Recommendation Report for Planning Permission

REF NO: LU/177/14/PL

LOCATION: The Old Dairy
Behind 3 & 5 Church Street
Littlehampton

PROPOSAL: Demolition of original dairy distribution depot and construction of 8 No. dwellings and ancilliary works. Resubmission following LU/298/13. This application may affect the character and appearance of the Littlehampton (East Street) Conservation Area.

SITE PLAN WITH DRAFT LEVELS
 PROPOSED RESIDENTIAL DEVELOPMENT
 THE OLD DAIRY, CHURCH STREET, LITTLEHAMPTON, SUSSEX.
 GRAHAM NICOLLS LIMITED, DESIGN + TECHNOLOGY, TEL/07990 522709

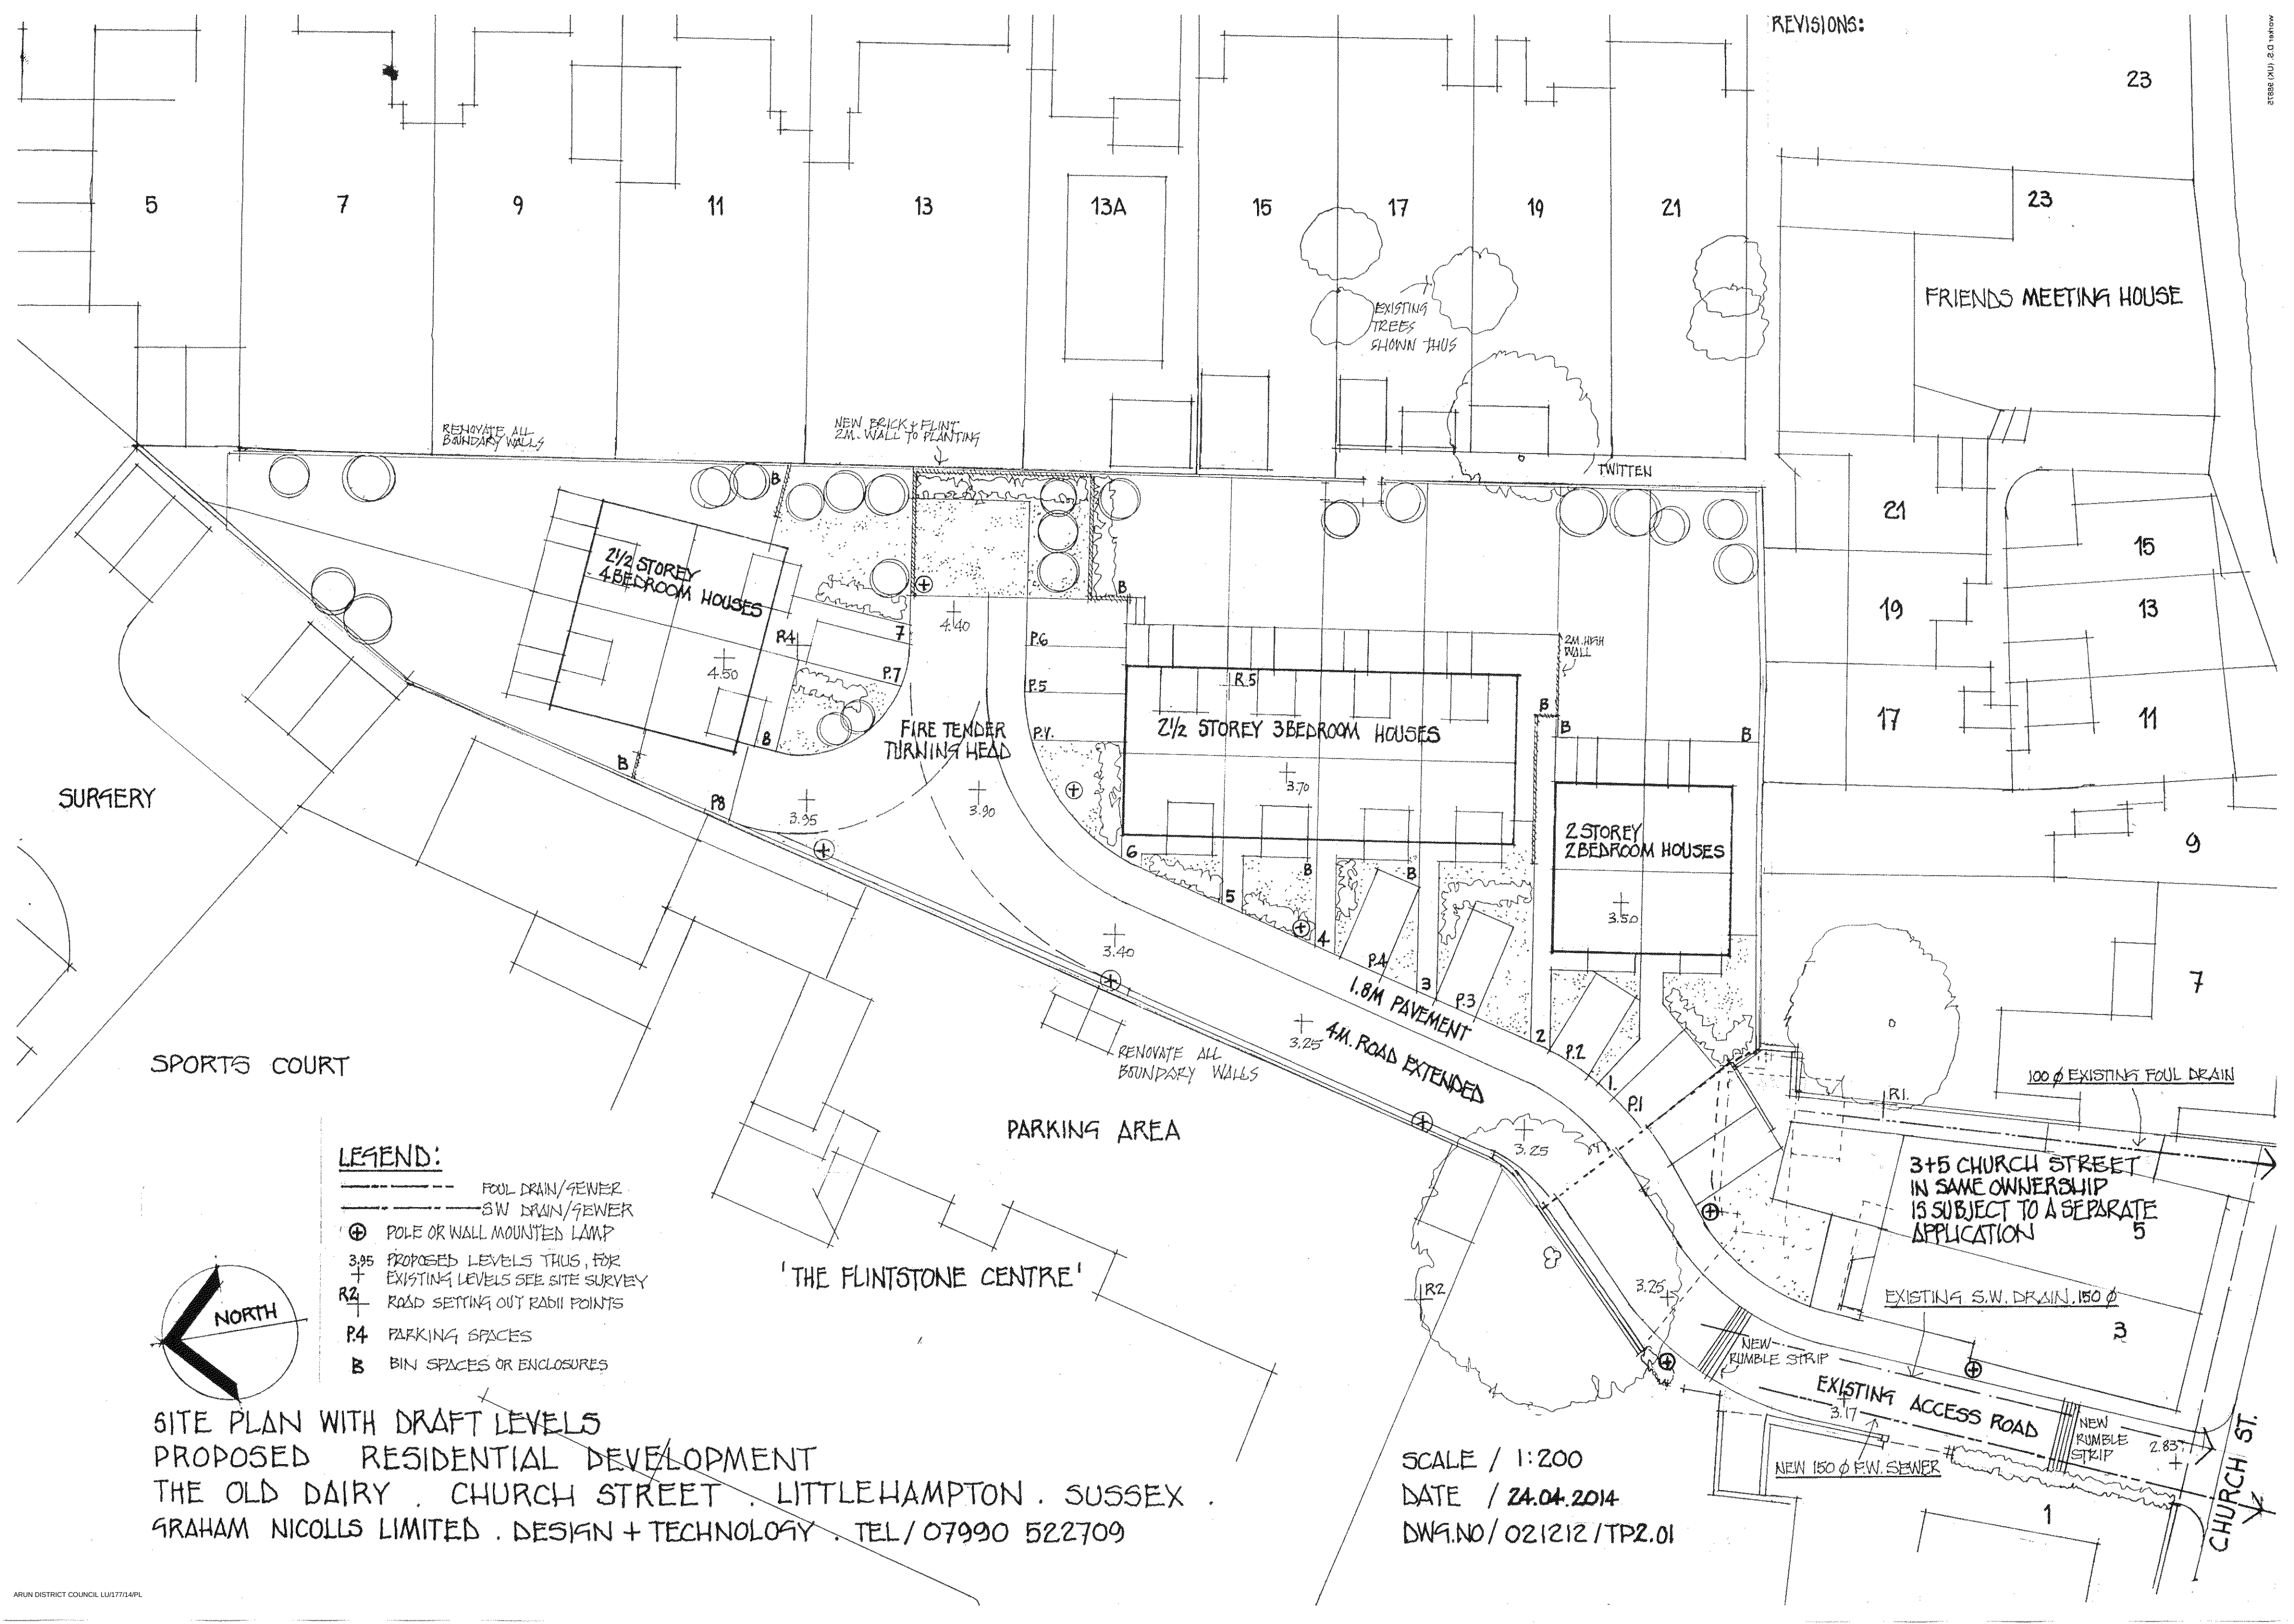
No objection to the principle of re-using the existing access for the development. This is subject to appropriate condition requiring additional information. There is concern about the internal layout to the development and the 4m wide carriageway looks narrow. It is also unclear if Plots 3 and 5 have their own driveway access onto Church Street. The site access should be kept free and unobstructed and there should be an obligation in the S106 agreement to have funds available for a Traffic Regulation Order for a period of 3 years should problems arise as a result of this development.

The proposed 8no. dwellings are not well spaced out across the site and so leads to a cramped and contrived layout. This is particularly the case with the small separation distance between the semi-detached pair (Plots 1-2) and the terraced row (Plots 3-6). Due to the number of dwellings being proposed in this size plot, this layout gives rise to an unacceptable overdevelopment of the site.

One effect of this cramped layout means that the vehicle spaces for Plots 1-4 run at an angle across the front gardens and appear to not be comfortably accommodated. It is therefore not accepted that this is an intended design feature of the development but rather the result of a lack of sufficient space for these dwellings, gardens and parking areas. This arrangement would therefore cause harm to the appearance of these properties and the development as a whole.

However, the concentration of development is towards the south of the site where it will be situated in relatively close proximity to the town houses of Nos. 17, 19 and 21 Church Street. These neighbouring properties have comparatively small rear gardens and with a separation distance of approximately 5m between Plot 1 and No. 17 Church Street, it is considered that this would cause harmful overbearing and overshadowing on this property.

Within the site, the layout of Plot 3 in respect to Plot 2 would cause unacceptable overshadowing, overbearing and loss of light on the property of Plot 2. This is due to Plot 3 projecting to the rear of Plot 2 by approximately 4m at a distance of only 2m away. This building arrangement would therefore conflict with the 45 degree rule which this Council has adopted for the determining of Planning Applications to ensure that any development does not seriously affect a neighbour's outlook or daylight to the rear.

Two of the proposed dwellings (Plots 4 and 5) have a rear garden area measuring 50 sq m instead of the required 65 sq m according to the external space standards. This is an unacceptable shortfall as the policy requirements must be met in full and so the proposal conflicts with policy D DM3 of the Emerging Local Plan.

PLOTS 7 AND 8 FRONT AND REAR ELEVATIONS
THE OLD DAIRY LITTLEHAMPTON
GRAHAM NICOLLS LTD. BUILDING DESIGN + TECHNOLOGY

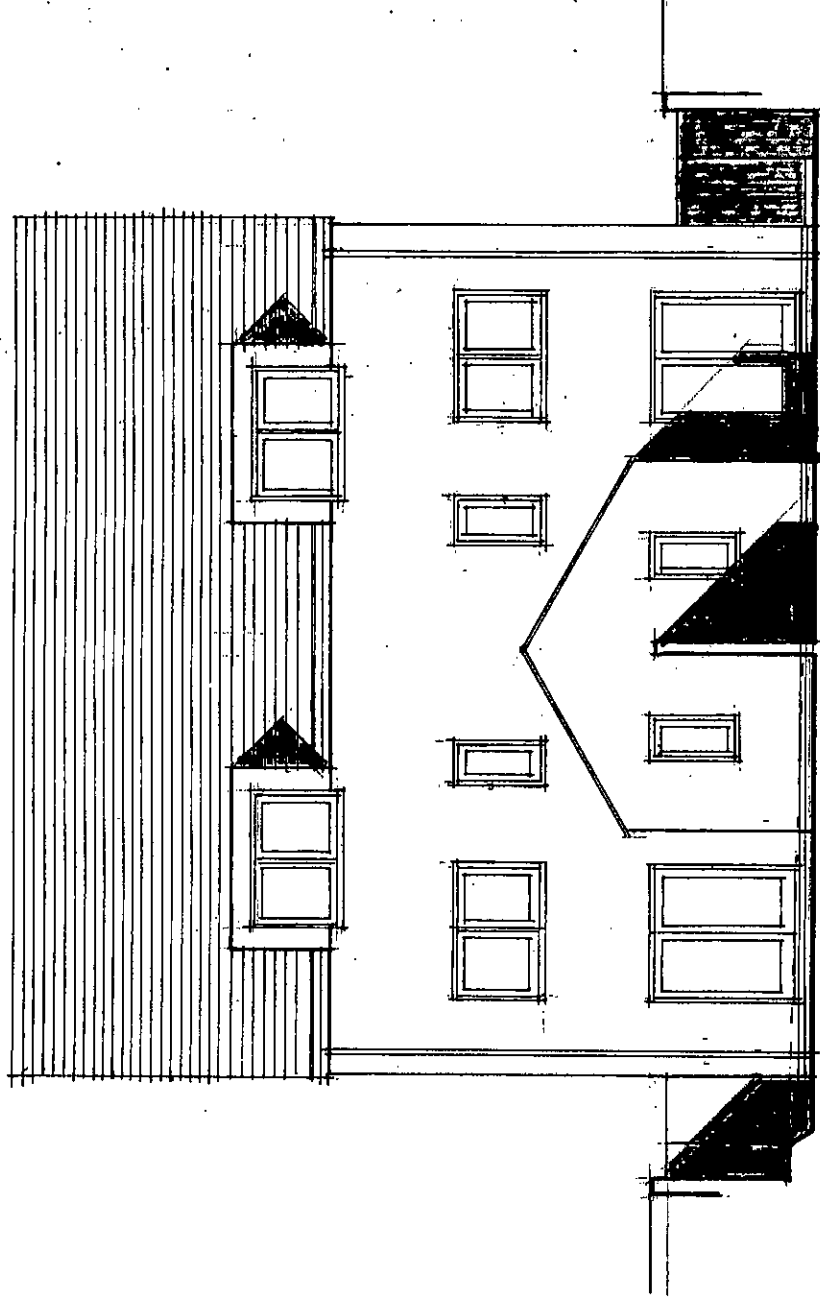
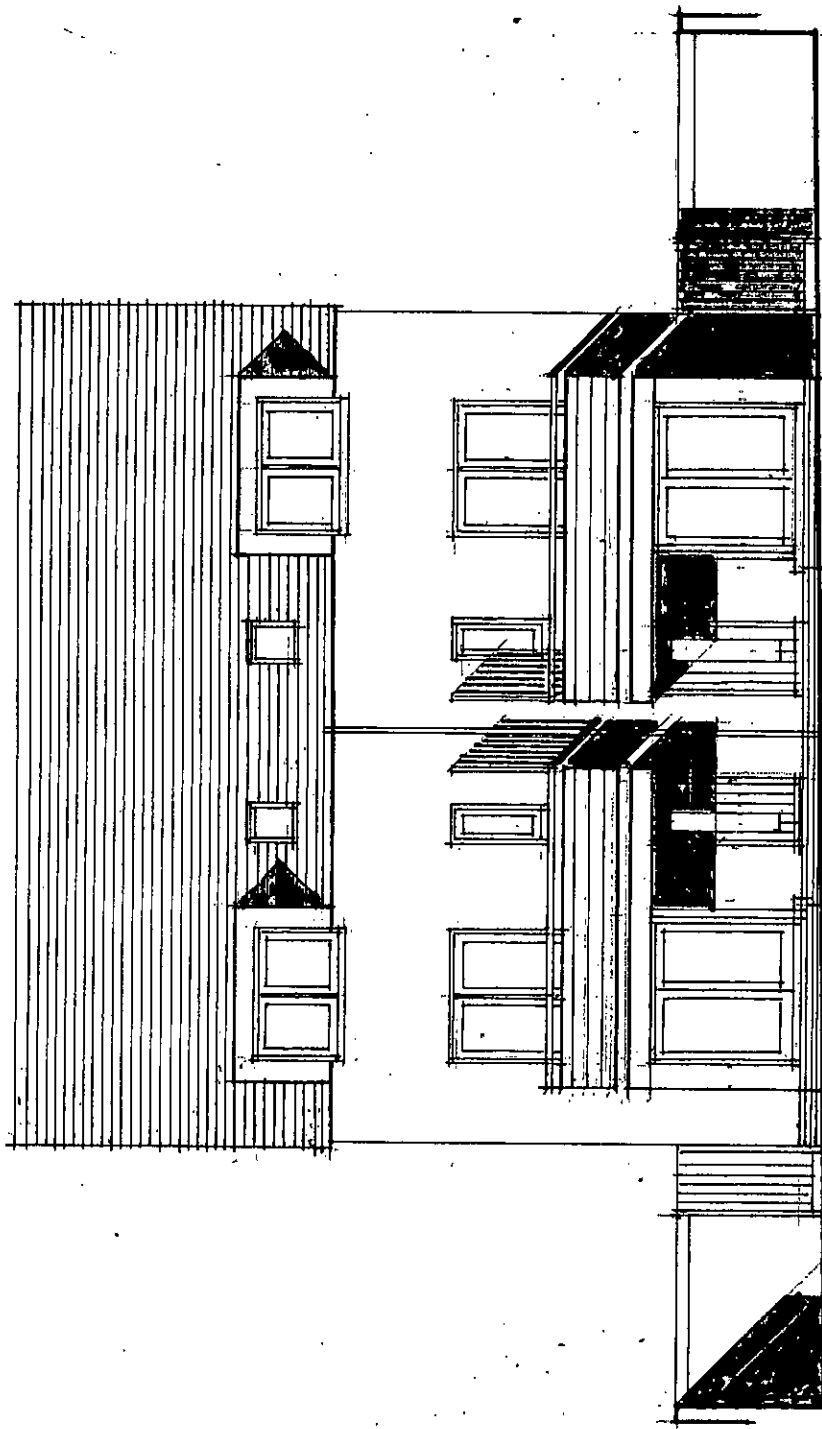
Six of the dwellings are proposed to be 2 1/2 storey in height (Plots 3-8). Whilst the actual heights of these dwellings will be very similar to those properties in Goda Road to the east, these are mainly two storey properties as well as the significantly smaller properties of nos. 11-21 Church Street to the south. It is therefore considered that the predominant development form of 2 1/2 storey properties will be out of character with its surroundings.
